Harnett County Government Complex  
307 W. Cornelius Harnett Boulevard  
Lillington, NC 27546

**Re: Status of Improvement Permit Application #13-5-30849 & #13-5-30896**

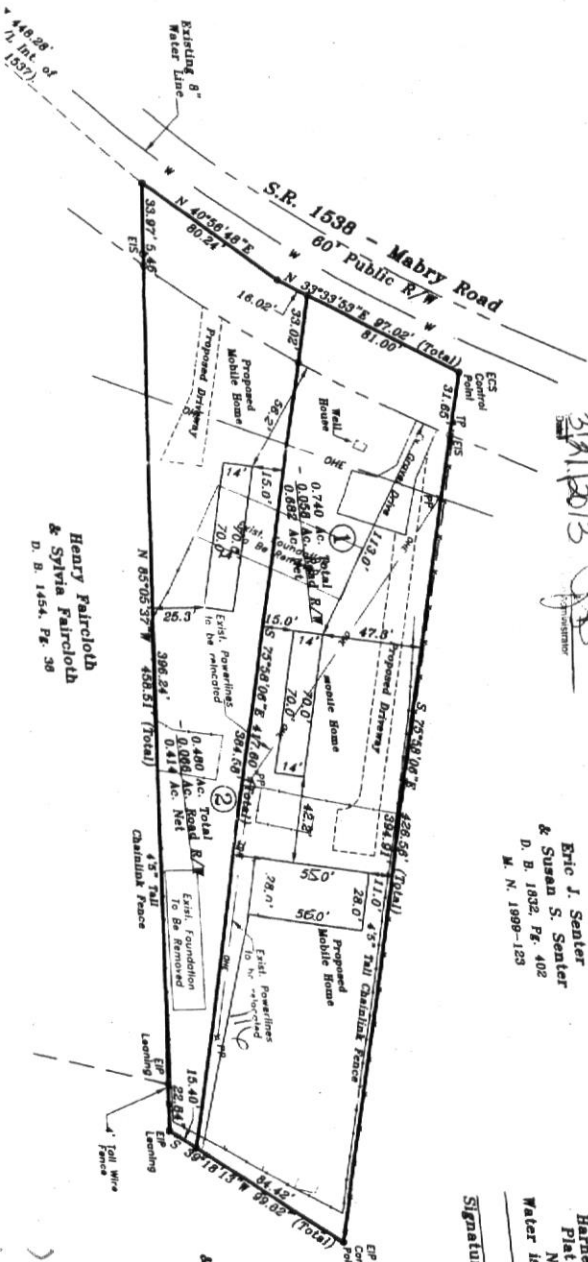
**7. Other – On lot 1 all garbage must be properly disposed of behind MH. Septic tank must be uncovered and distribution box uncovered. (May need to locate drain lines) The 90 ft. easement must be marked.**

**Both applications refer to proposed septic tanks as being on lot 2 although site plan show 2 lots (1 and 2). Call me between 8-9 a.m. to discuss these items mentioned.**
